Our Ref: AL/72/14/HH
Your Ref:

Application for Planning Permission for Works or Extension to a Dwelling

Development Roof extension with new staircase over single storey accommodation & extension on west elevation.

Location Caigers Cottage Westergate Street Aldingbourne

LOCATION PLAN 1:1250@A1

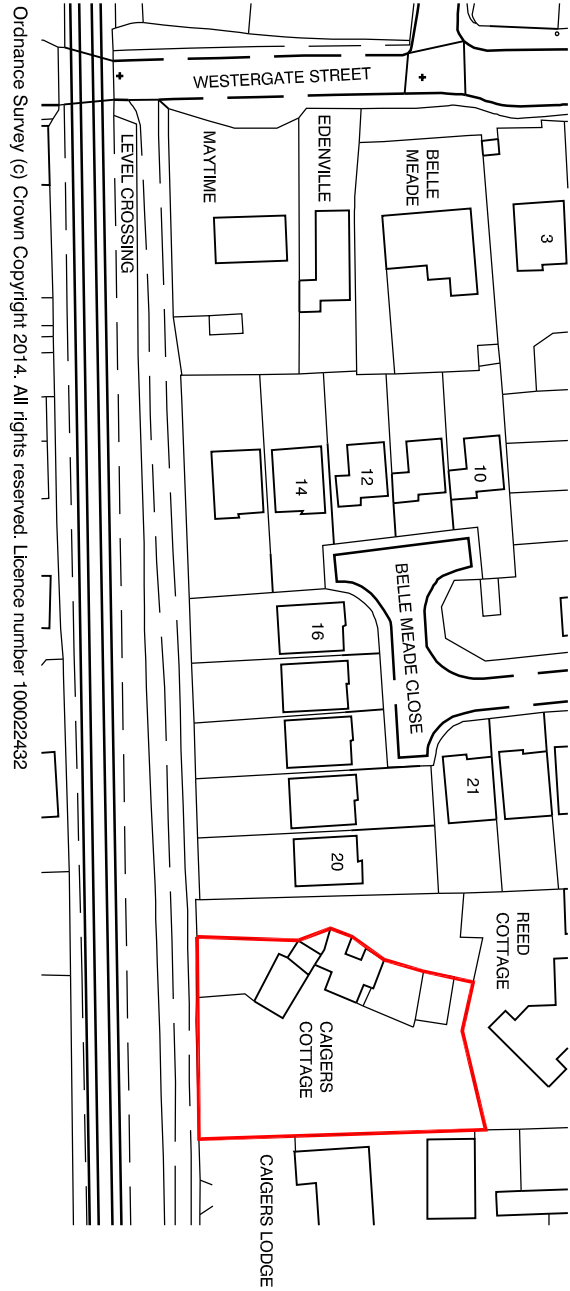
Location Plan

Please submit 1 electronic or 3 paper copies of a location plan at a scale of 1:1250 or 1:2500 for rural areas. Further details of what must be included on the plan can be found in the National Validation Requirements. Please provide two named roads.

SITE PLAN 1:200

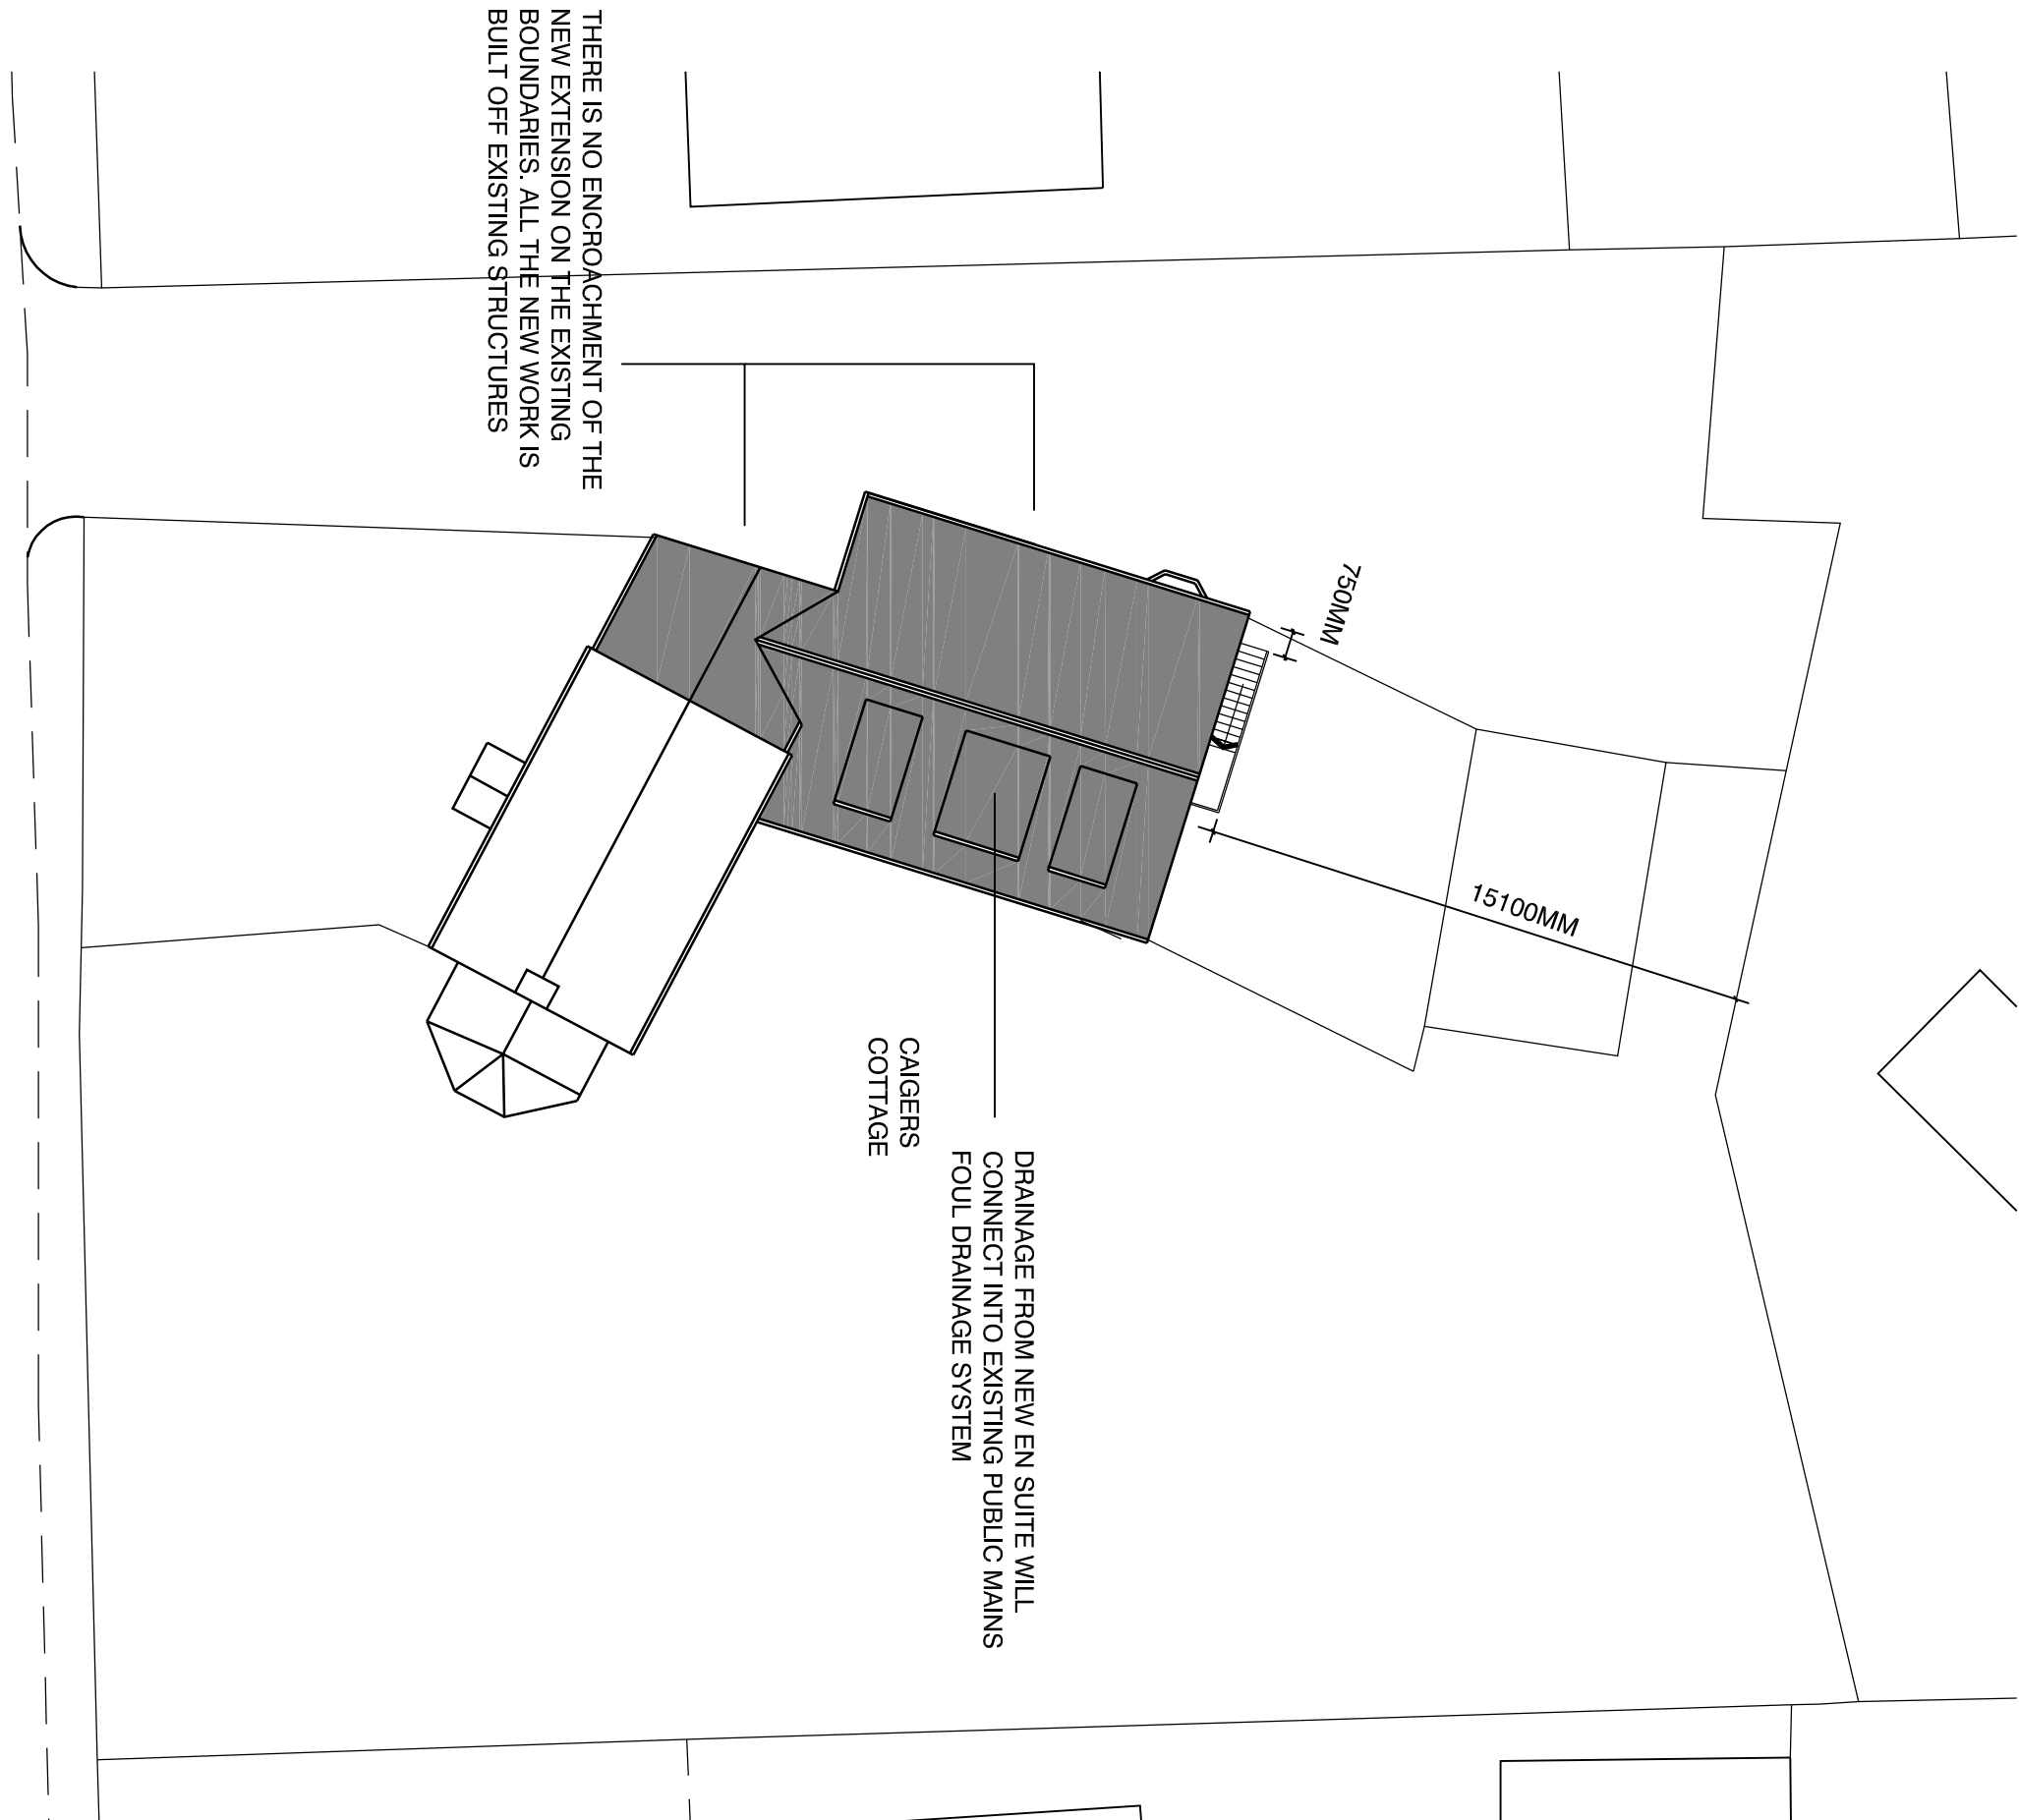
Please provide one named road, highlight the proposed works and provide measurement from the proposed ground floor extension to the site boundaries on the site plan.

BLOCK PLAN 1:500

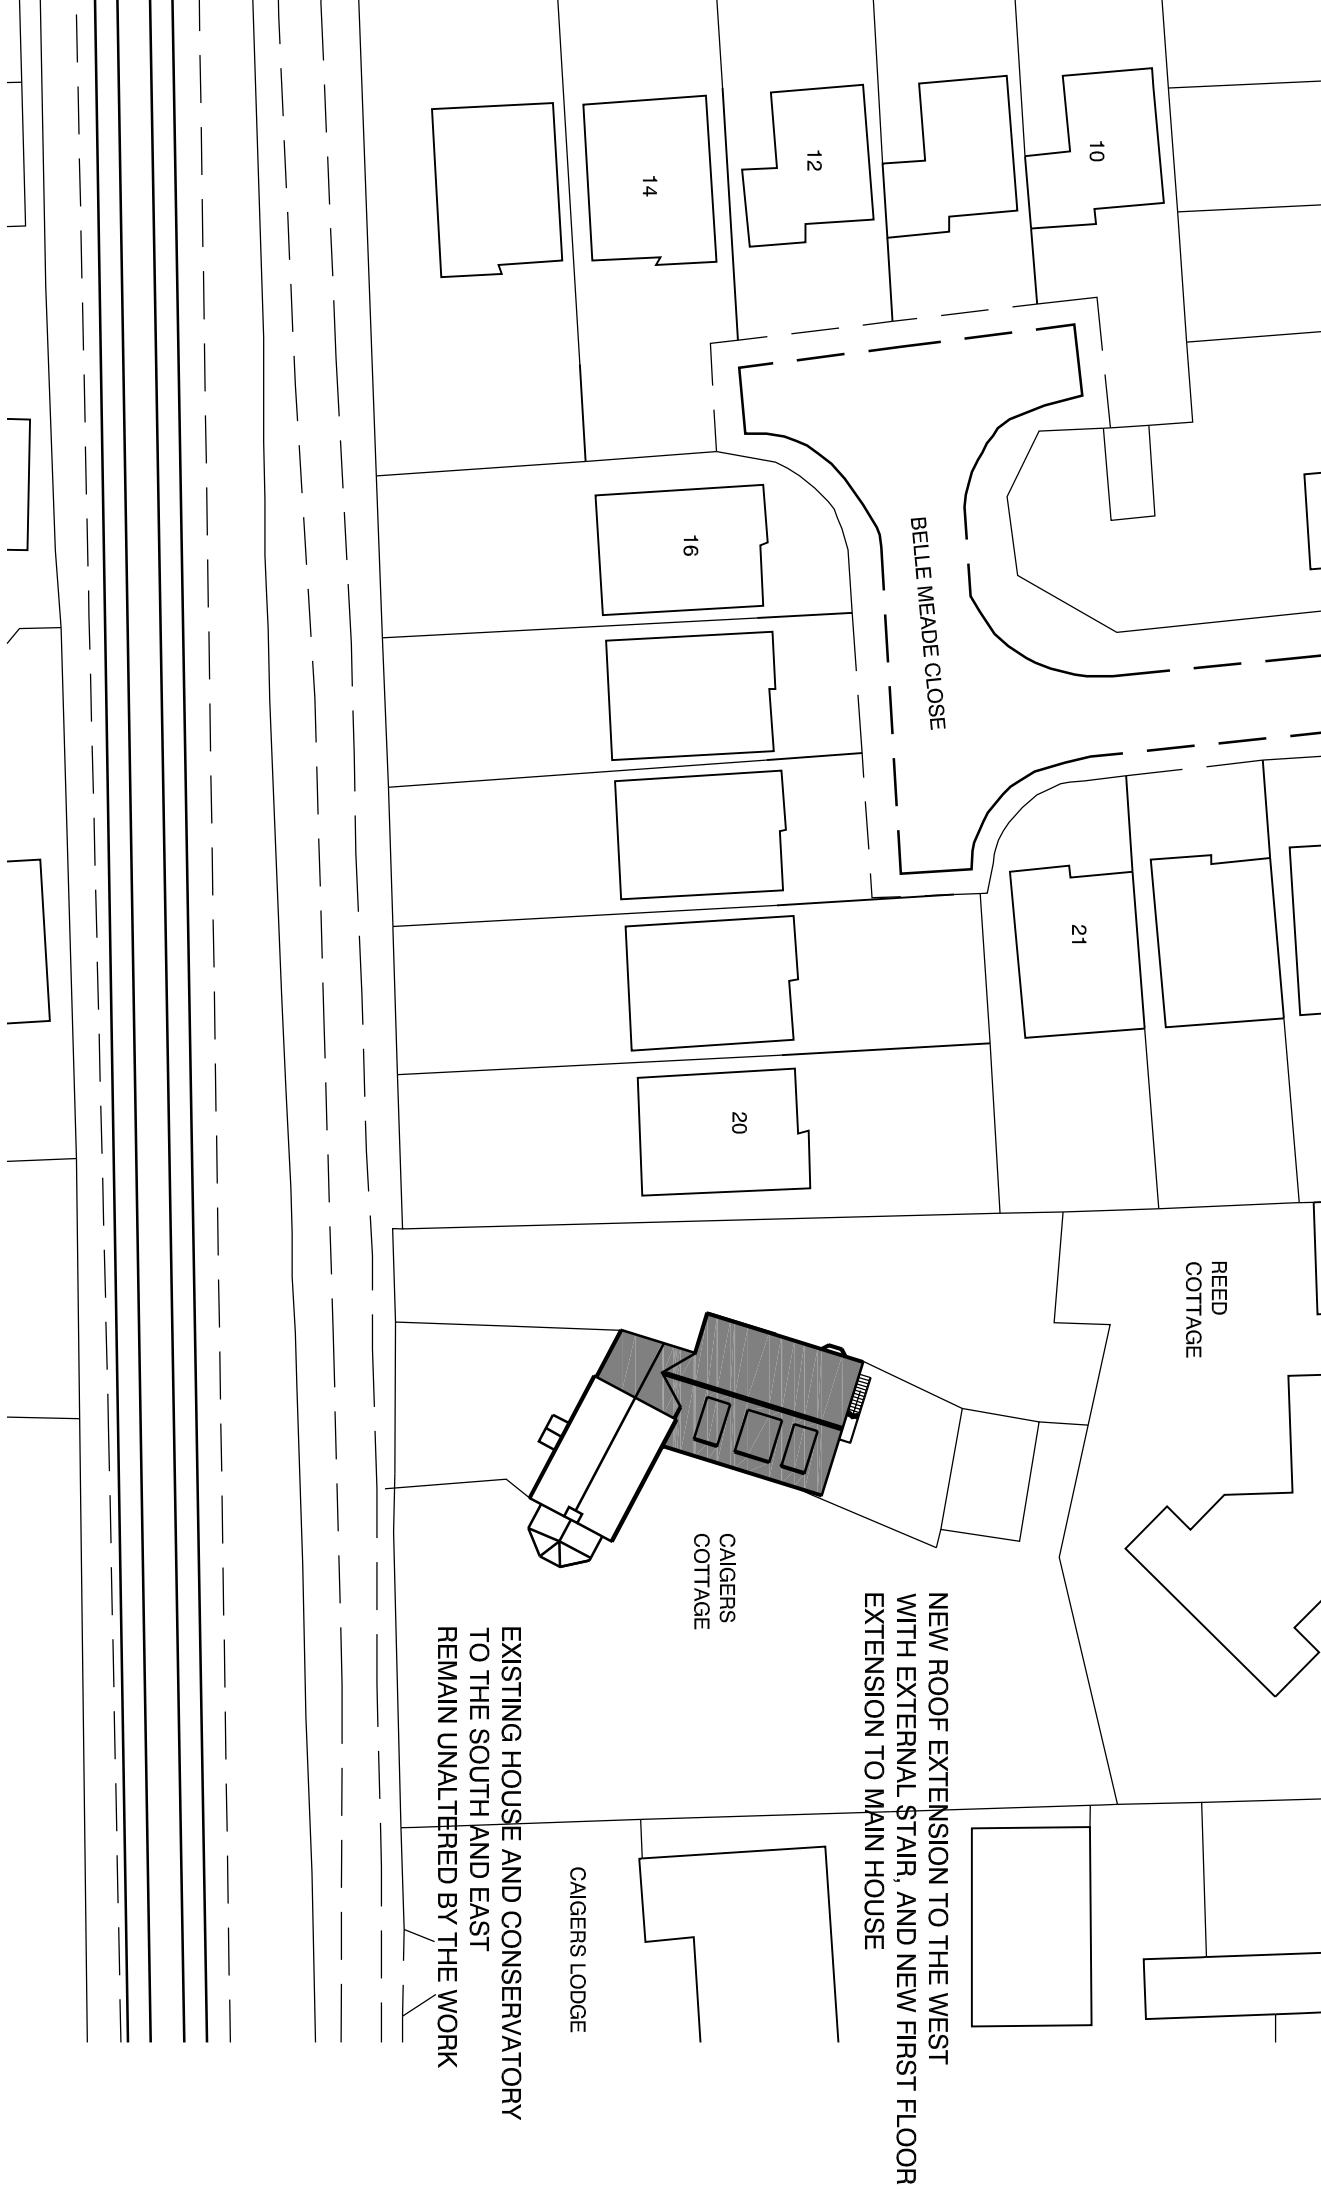
Block Plan

Please submit 1 electronic or 3 paper copies of a block/site plan at a scale of 1:500 or 1:200. Further details of what must be included on the plan can be found in the National Validation Requirements. Please provide one named road.
